From: Maria Tomalova <Maria.Tomalova@arun.gov.uk>
Sent: Wednesday, September 13, 2023 5:52 PM
To: Planning.Responses <Planning.Responses@arun.gov.uk>
Subject: FW: Stakers Farm

From: Martyn White <Martyn.White@arun.gov.uk>
Sent: Thursday, June 18, 2020 11:07 AM
To: Maria Tomalova <Maria.Tomalova@arun.gov.uk>
Subject: RE: Stakers Farm

Site Layout

Drawing Title
Existing and Proposed Elevations - Barn 3

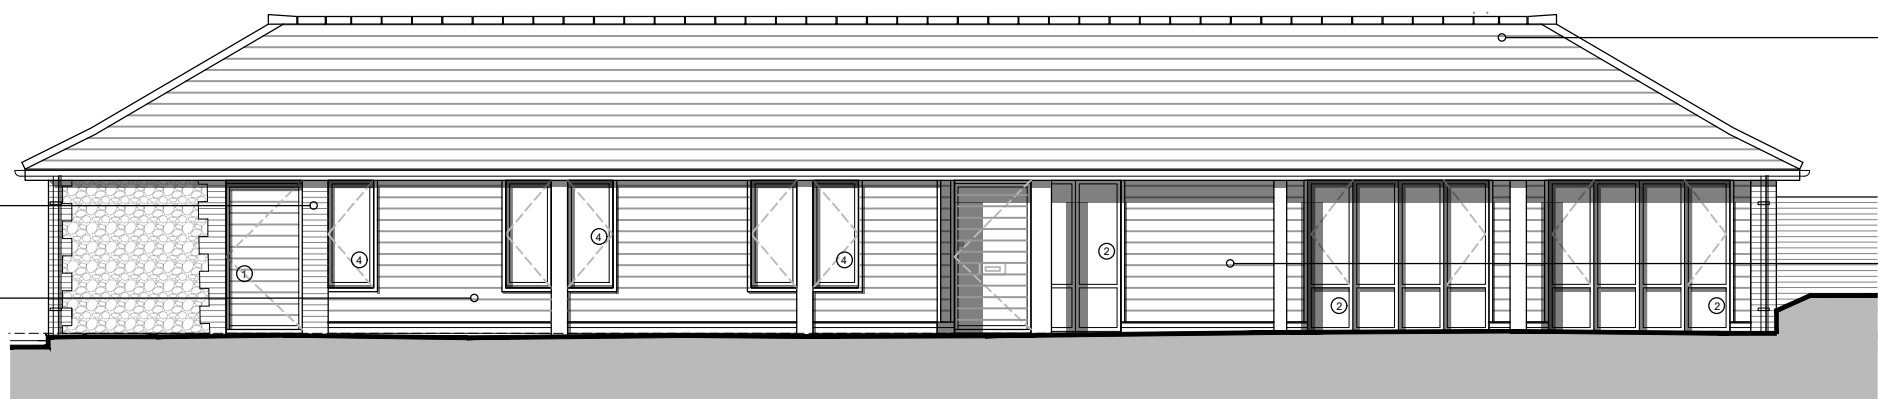
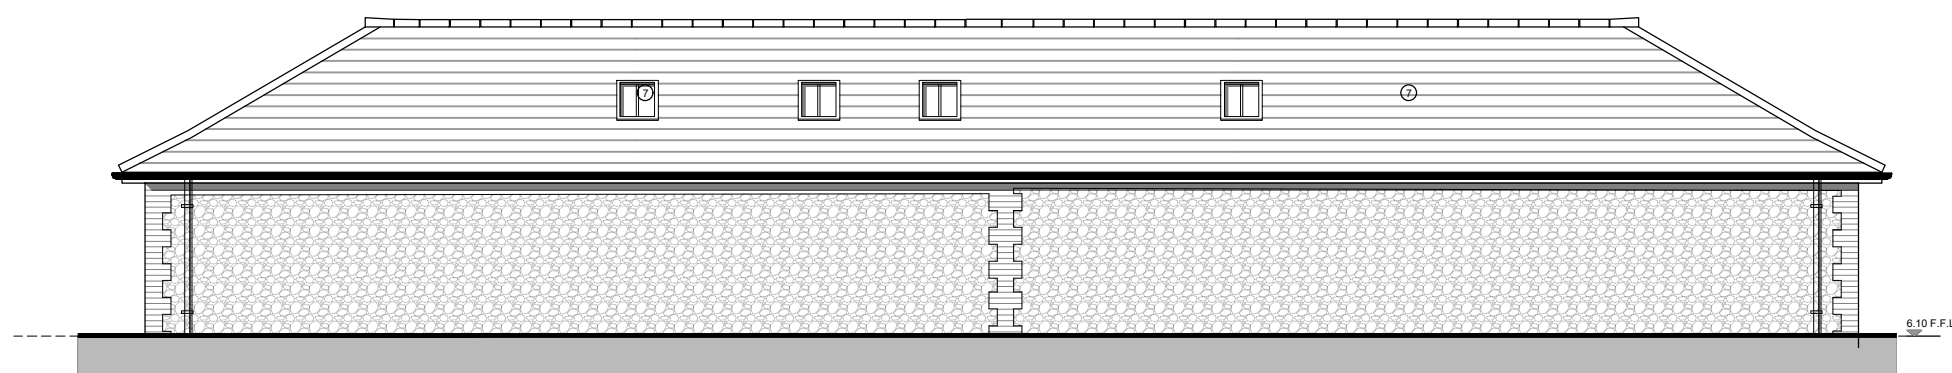
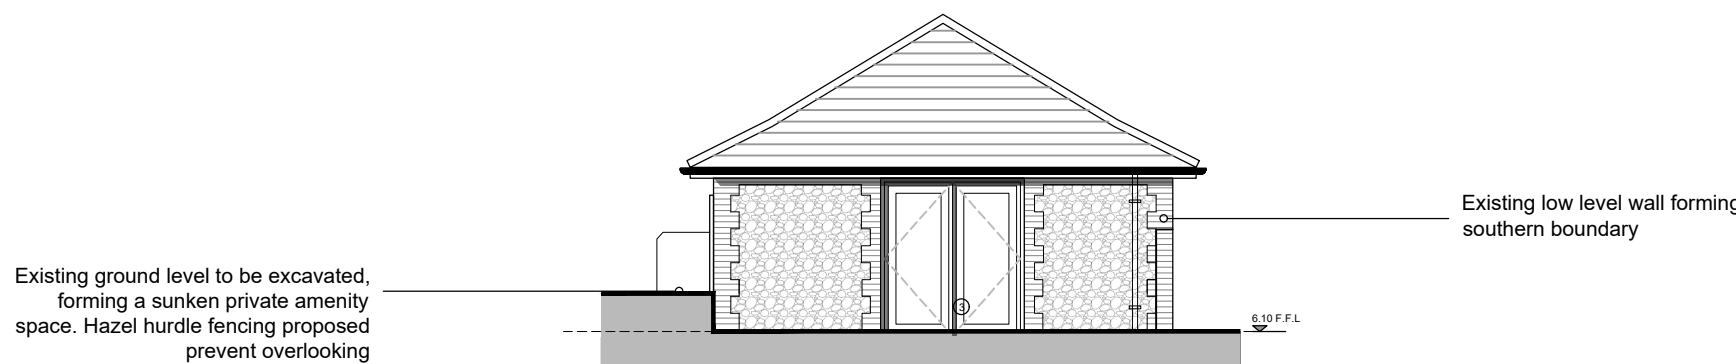
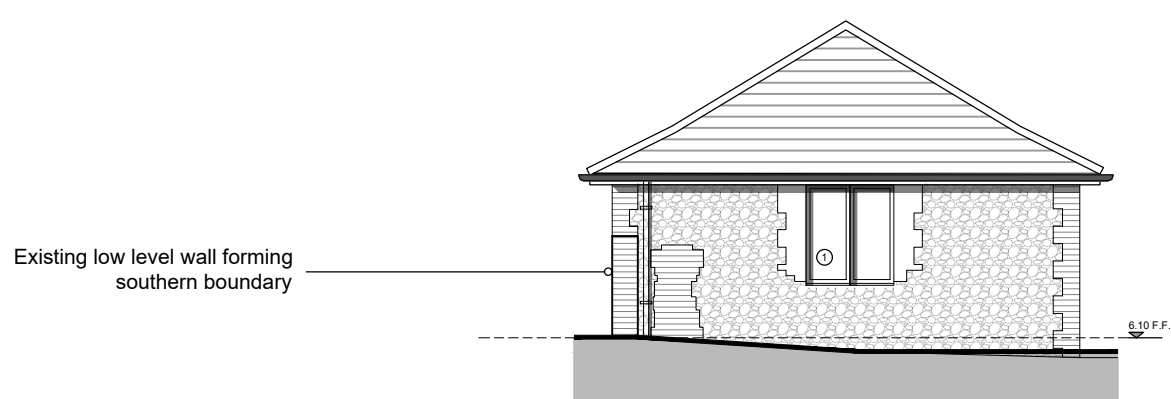
As I recall, no amendments to the drawings were required for this barn – previously there was a bi-folding door, but I believe this is to be removed?
